Town & Country Planning Act 1990 (as amended)
Town and Country Planning (Development Management Procedure) (England) Order 2015
Approval of details reserved by condition imposed under ref FG/52/18/PL relating to Condition No 4
surface water drainage.
Quercus Nursery Littlehampton Road, Ferring,

Arun District Council have decided to **REFUSE** details reserved by condition for the following reasons:

The drainage proposals are inadequate.

Figure 1

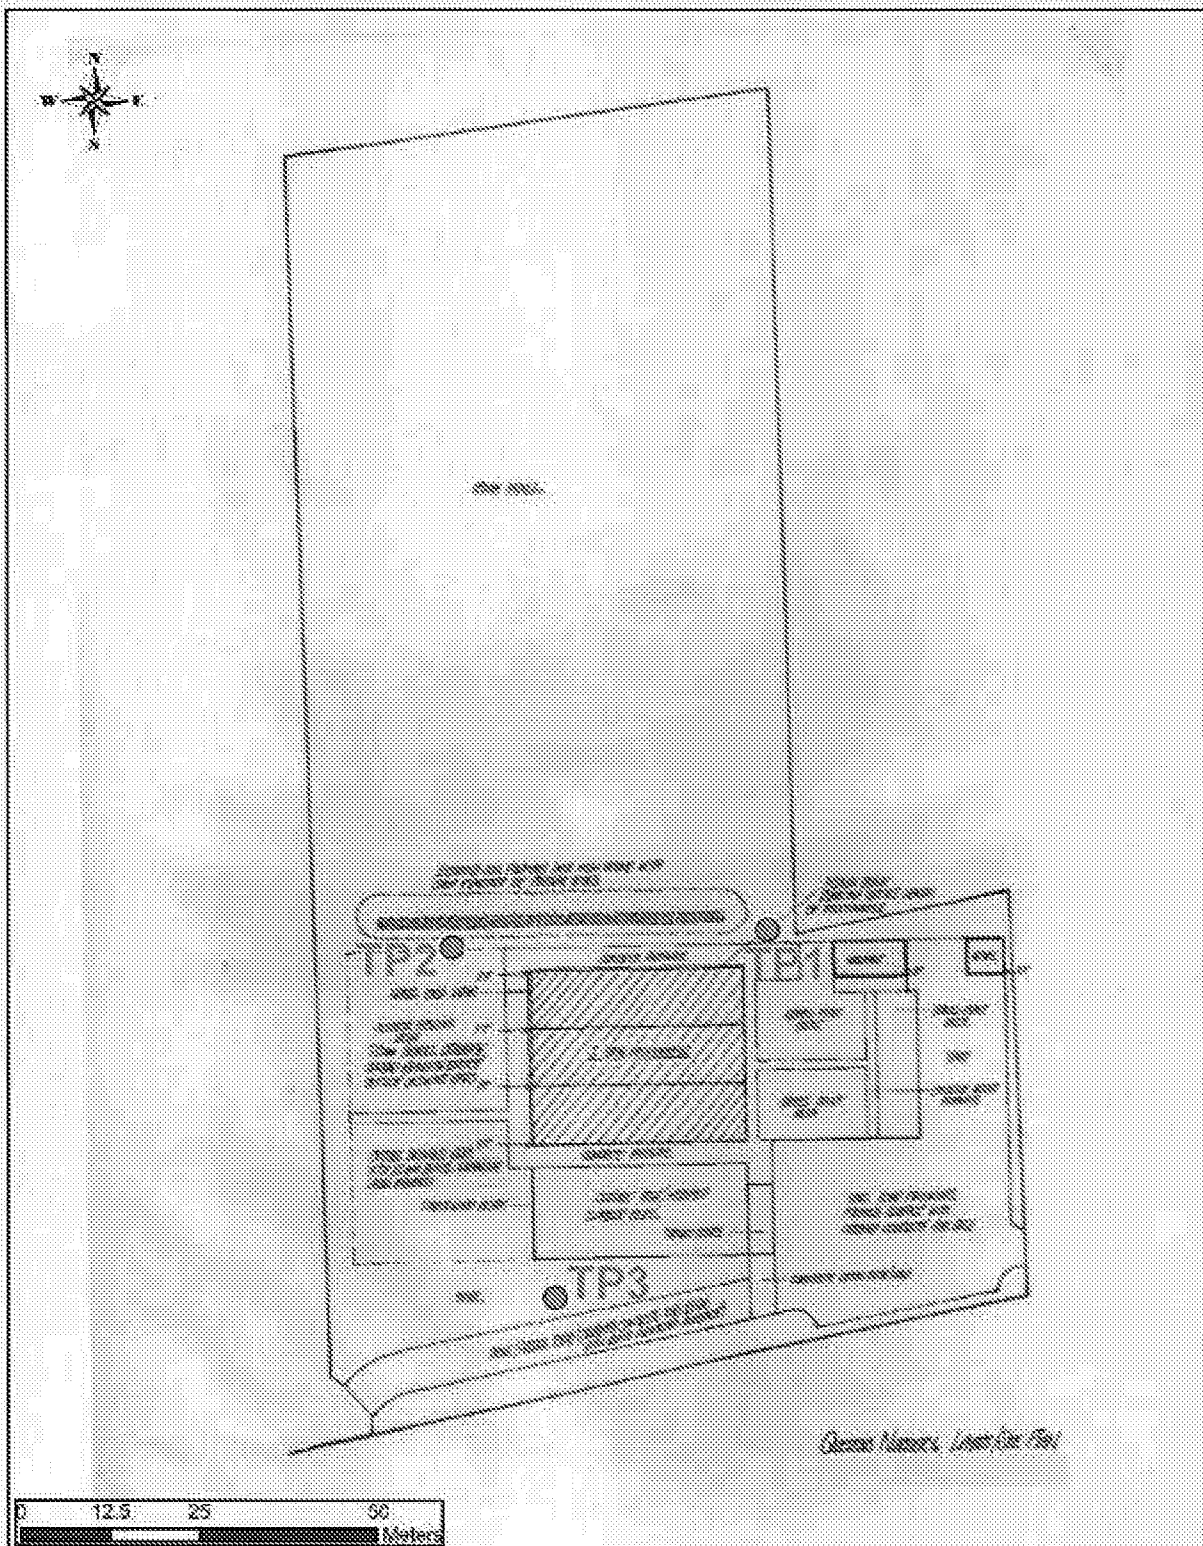
1. A 40% allowance for climate change must be applied. The 20% allowance used does not meet current policy requirements. This was highlighted in my original comments to FG/52/18/PL.
2. Infiltration testing is inadequate with only one test being completed at each pit location. As highlighted by the condition testing must be conducted in the winter and in accordance with BRE365. BRE365 requires three repeat tests to be completed at each location. The worst result from these results should be used in design.
3. No winter groundwater monitoring results have been supplied with the application. This information must be provided to enable review of the efficacy of drainage proposals.

Figure 3

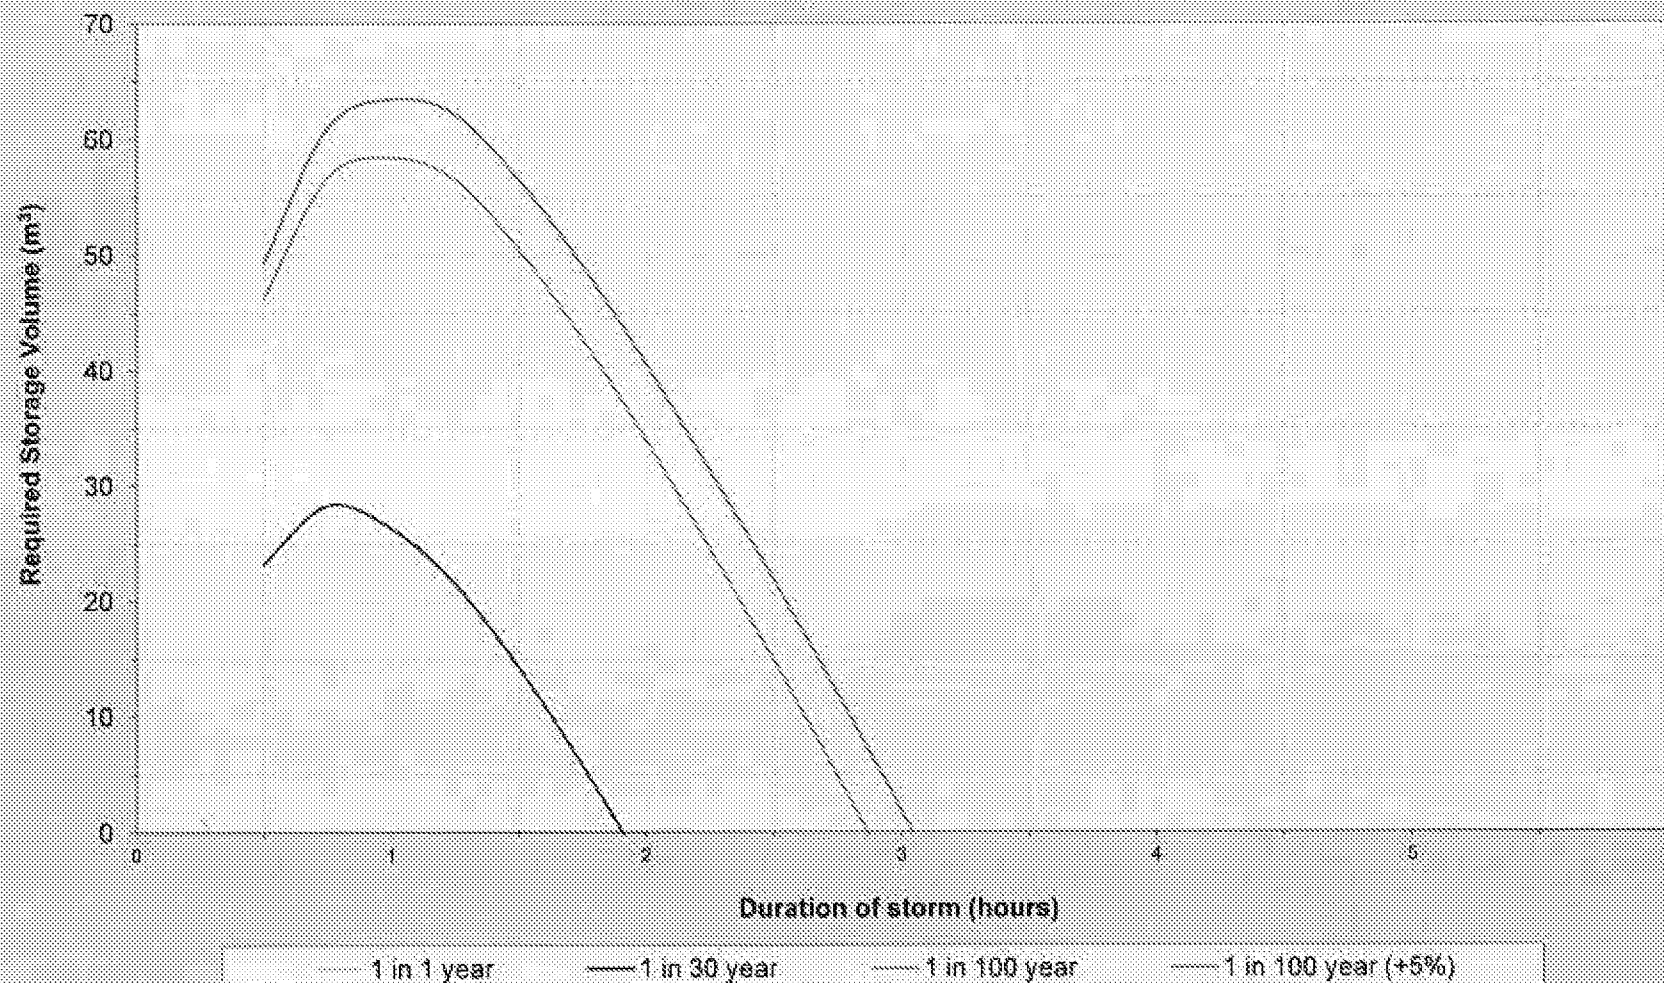
4. A crushed concrete subbase is proposed for the road. Yet no details as to size of this material are given. No fines should be present as this will result in an almost impermeable surface being formed. Please ensure construction detail drawings with exact material specifications stated.
5. No calculations have been provided which demonstrate the adequacy of design.
6. Drainage layouts need to be updated to ensure they meet the requirements set out in our checklist.
